Development Facilitation Team (DFT) – Review Comments

Project No: PR-2023-008616

Application For: SD-2023-00154 – PRELIMINARY/ FINAL PLAT (DHO)

DRB Project Number: 2023-008616
7805 Aguila

Site Plan

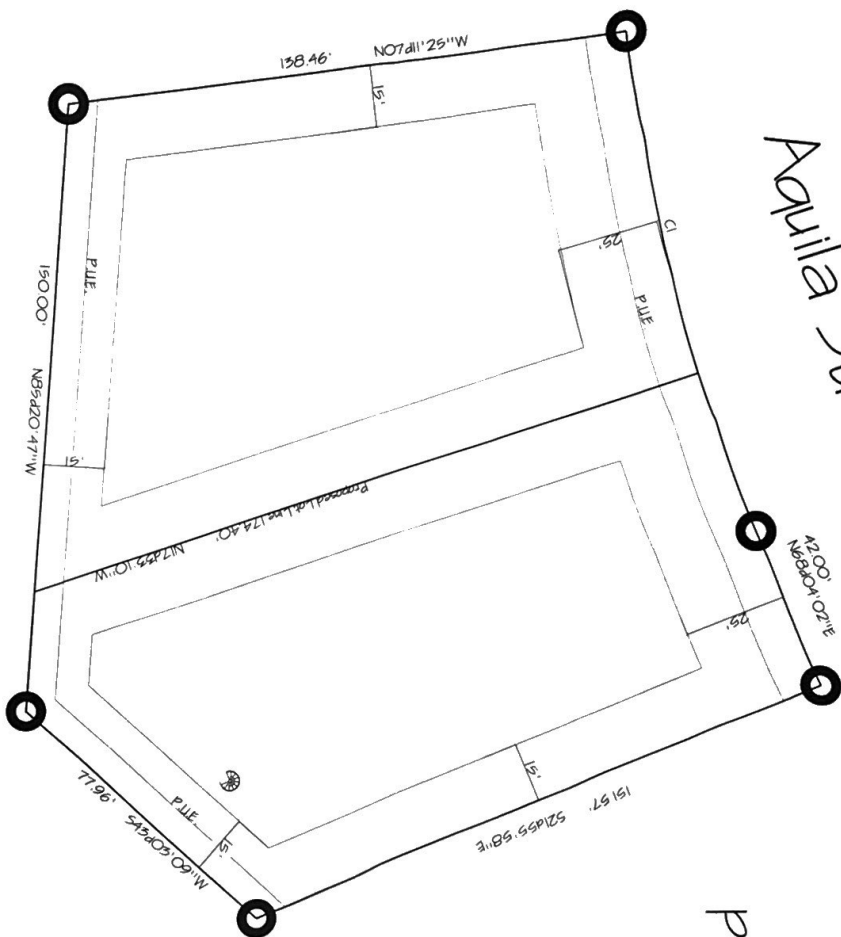
1. Aguila is a local road which requires 5' sidewalk with a 4-6' landscape buffer. Please provide a diagram showing the existing sidewalk and landscape buffer to show if it meets standard.
